### **UNSW Health Translation Hub (SSD-10822510)**

Thank you for your correspondence via the Major Projects Portal on 17 May 2021, requesting Transport for NSW (TfNSW) to review and comment on the above.

Figure 12 Pedestrian access
Image Source: Architectus

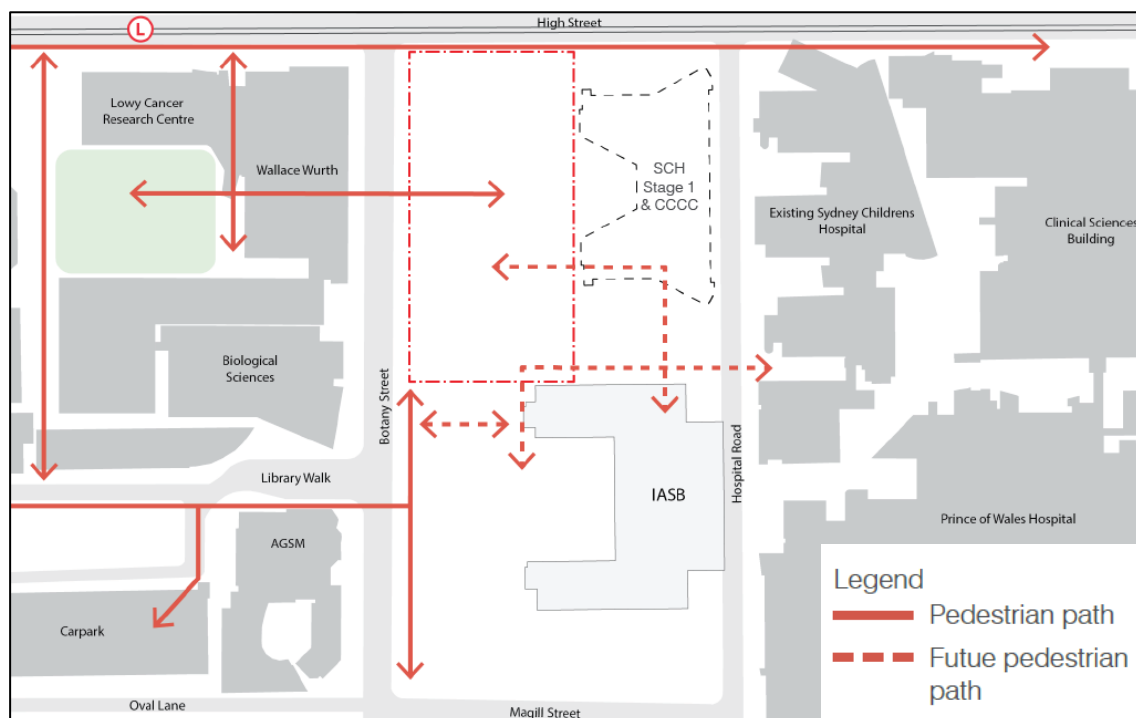
Details on how the pedestrian bridge over Botany Road will be constructed to minimise impacts on all road users should be provided.

Figure 19 Proposed Botany Street drop off / pick up area

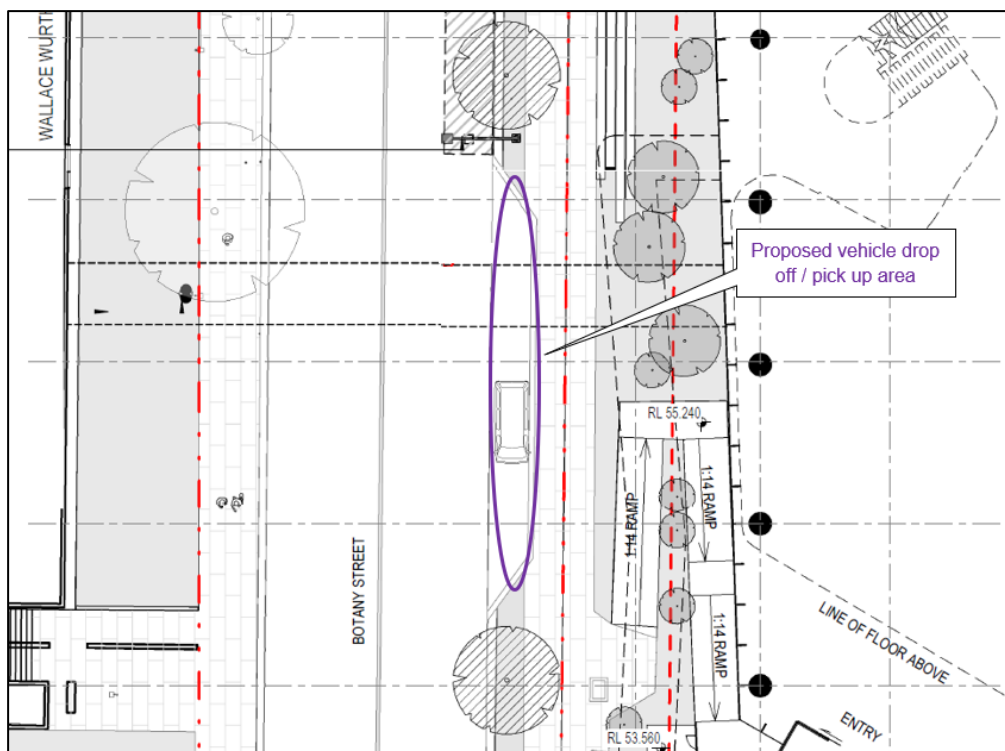
Section 5.6 of the Transport Impact Assessment prepared to support the development application states the following:

*“It is proposed that approximately 20m of this 1 hour parking zone is redesignated as 5 minute parking (or similar) to facilitate pick up and drop off movements.”*

It is advised that kerbside restrictions are determined based on balancing needs of all users and are constantly subject to change and the proponent should not rely on the need for the suggested designated kerbside use.

It is requested that the applicant provides further detail on the point to point demand, how it would be managed, including the potential need for on-site provision to meet the demand as part of the Response to Submissions.

Appendix A: Vehicle Swept Path Analysis

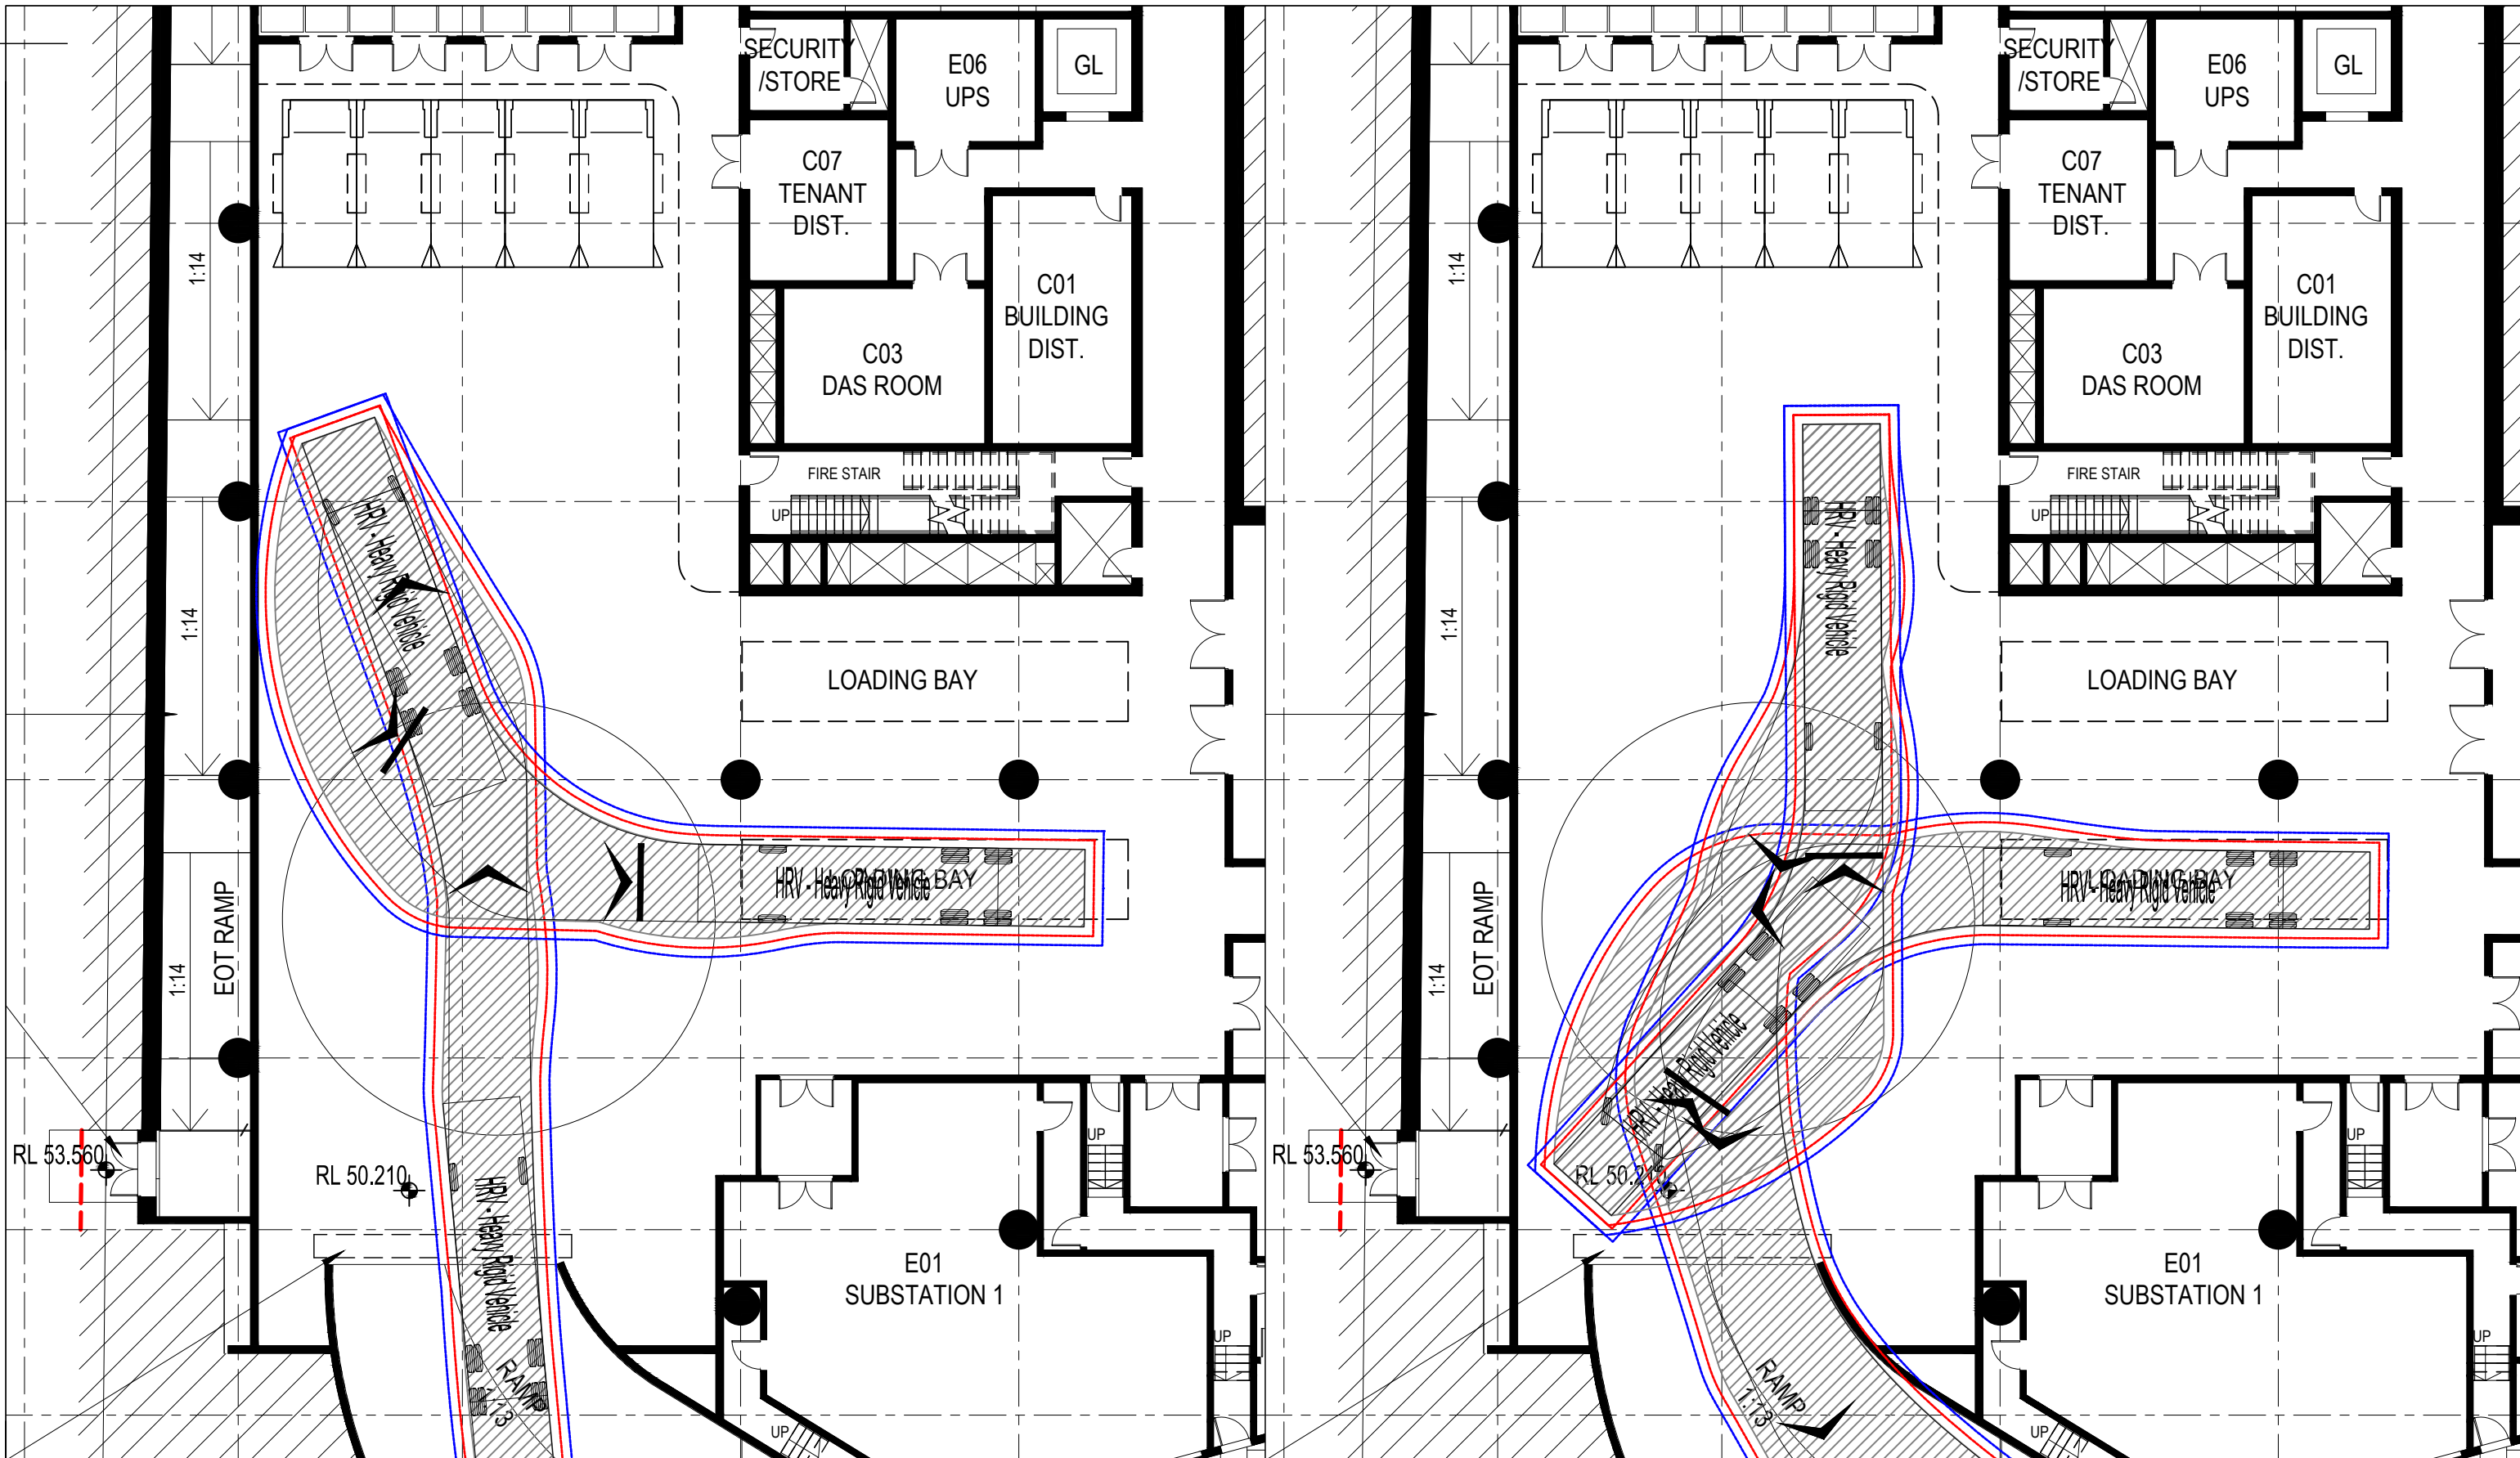
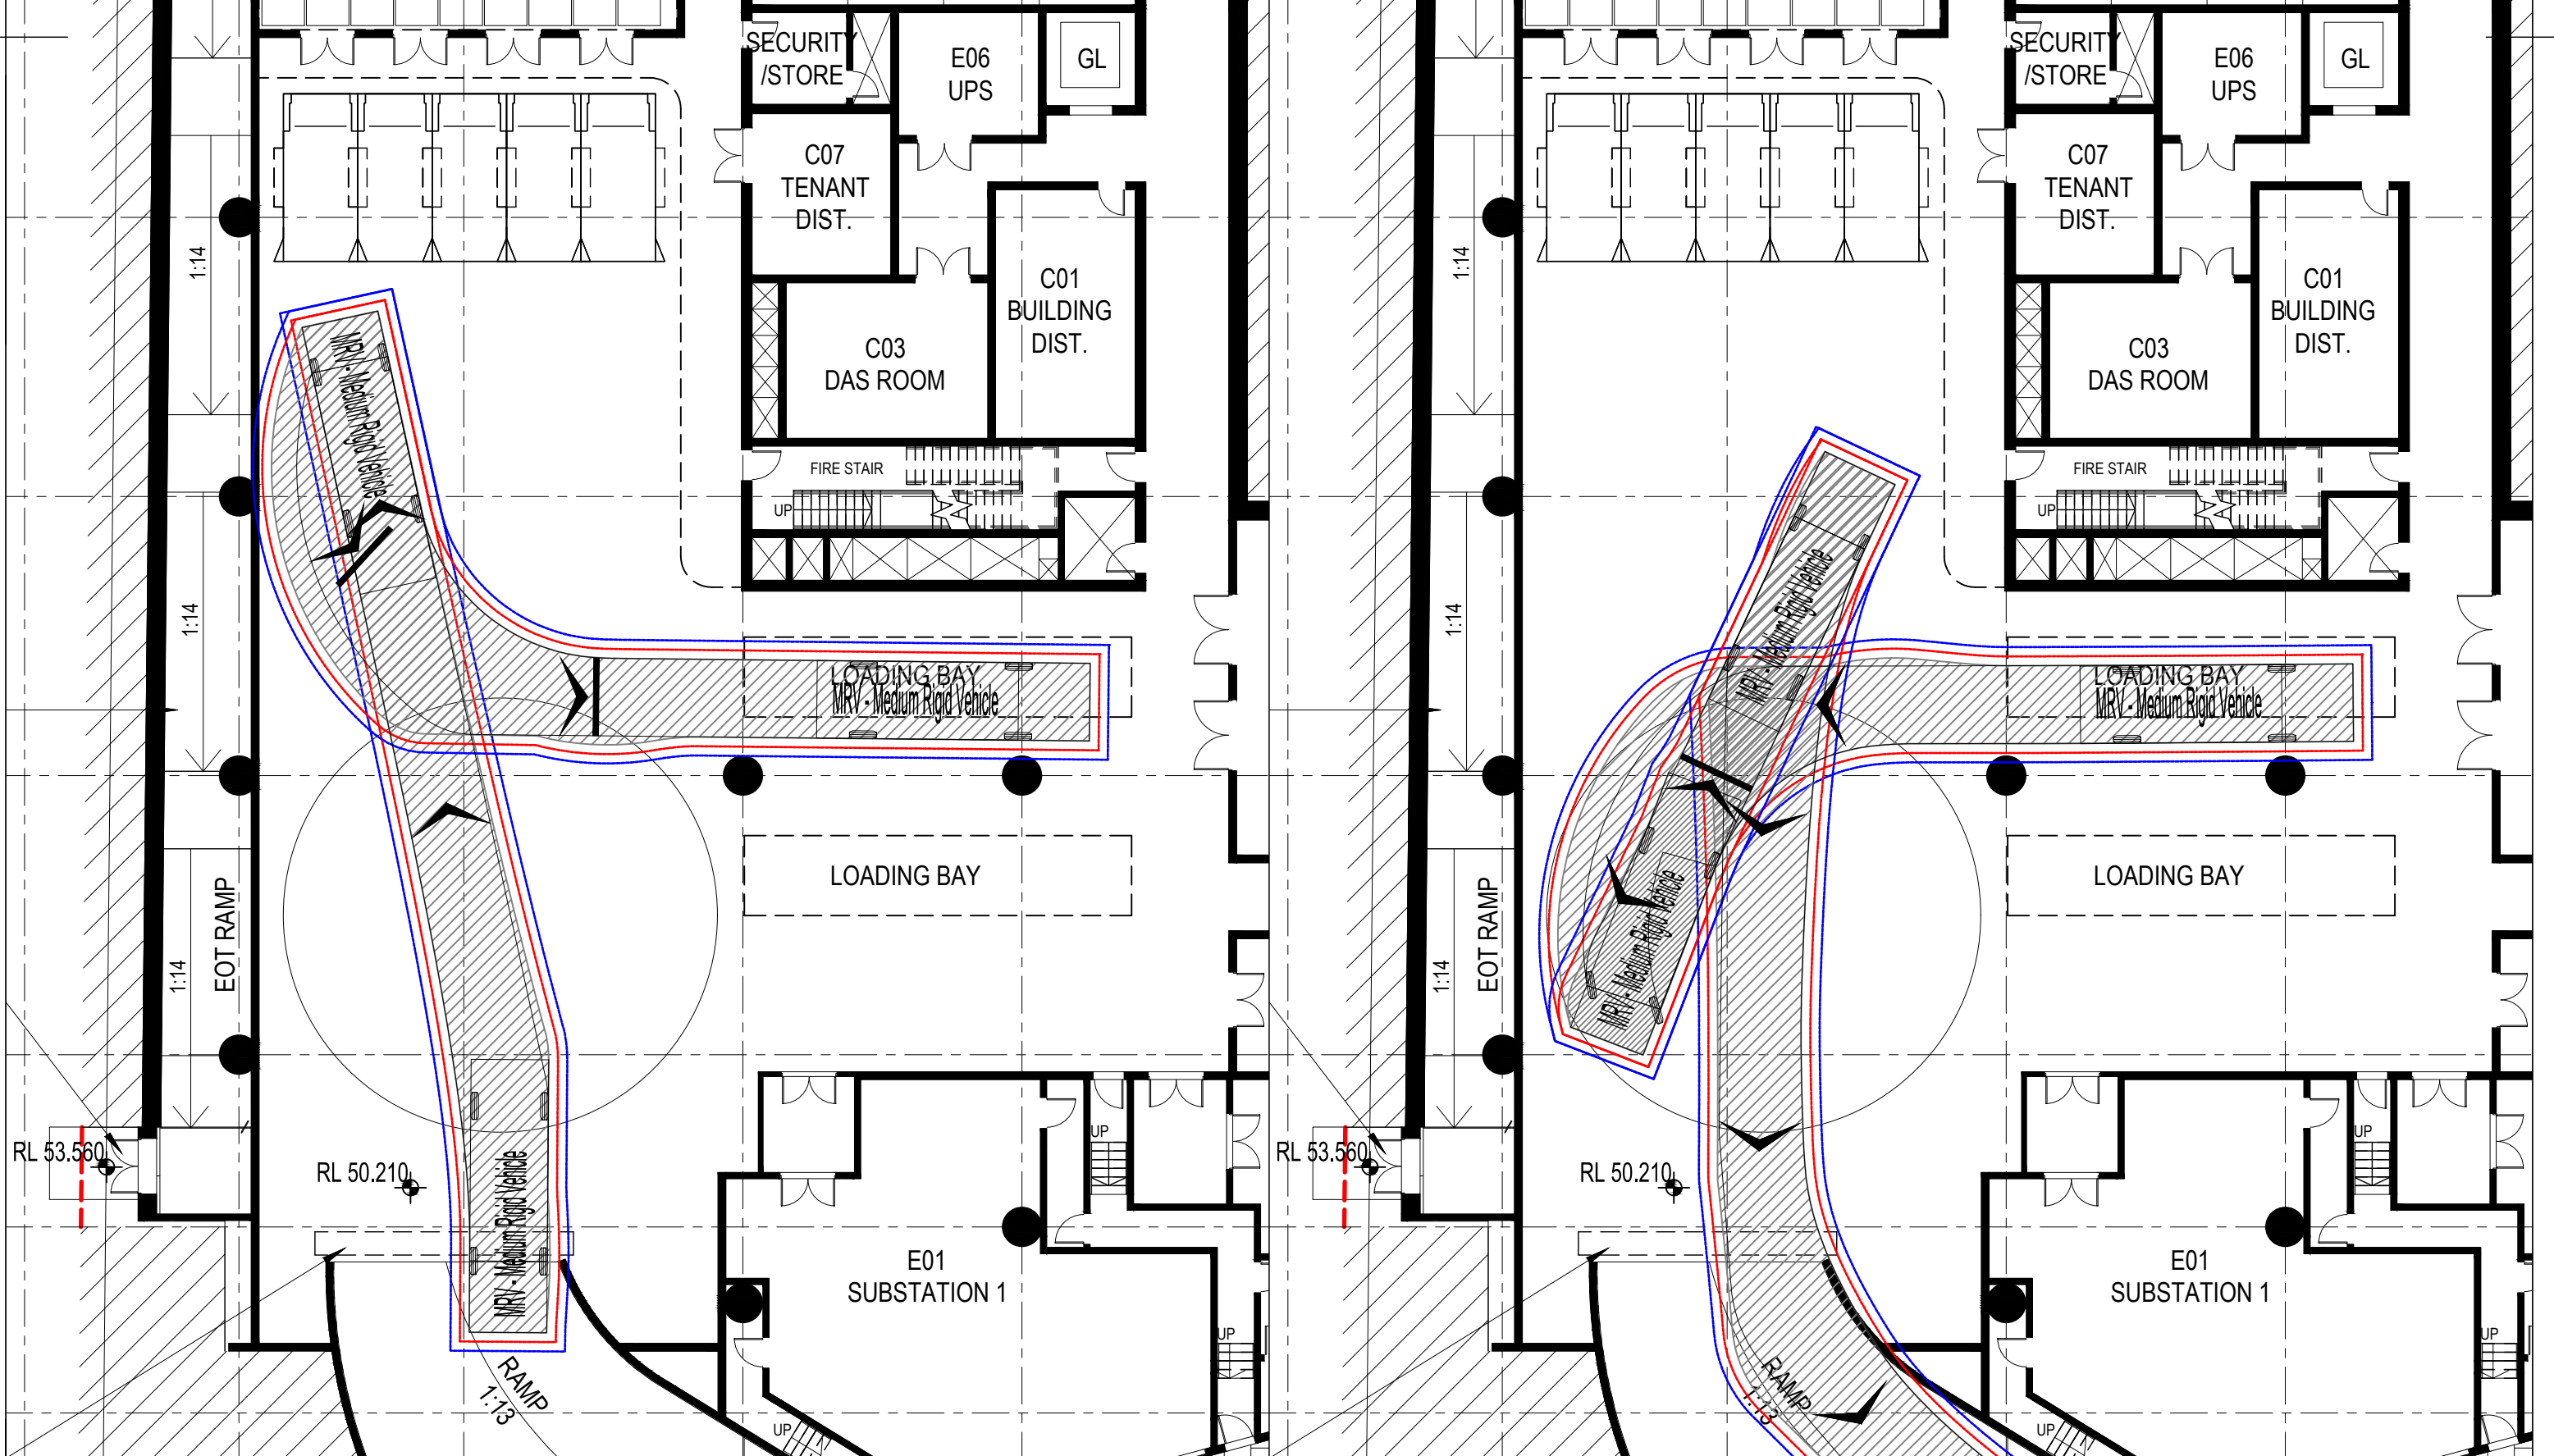
Appendix A of the Transport Impact Assessment includes swept paths of the service vehicles within the loading dock. However, a swept path analysis has not been undertaken for the maximum size of the service vehicles (Heavy Rigid Vehicle) entering and leaving the loading dock via Botany Street.

- Consider providing a consolidated loading dock for the subject site as well as the Children's Hospital Stage 1 and Children's Comprehensive Cancer Centre with access via Hospital Road. This is to remove the heavy vehicle access via Botany Street;
- A Stage 2 (Concept Plan) Road Safety Audit for the proposed vehicles and pedestrian access arrangement to the subject site in accordance with *Austroads Guide to Road Safety Part 6: Managing Road Safety Audits* and *Austroads Guide to Road Safety Part 6A: Implementing Road Safety Audits* by an independent TfNSW accredited road safety auditor; and
- A swept path analysis for Heavy Rigid Vehicles entering and leaving the loading dock to / from Botany Street.

Based on the results of the road safety audit and the swept path analysis, the design drawings need to be reviewed to identify safety measures that may need to be implemented.
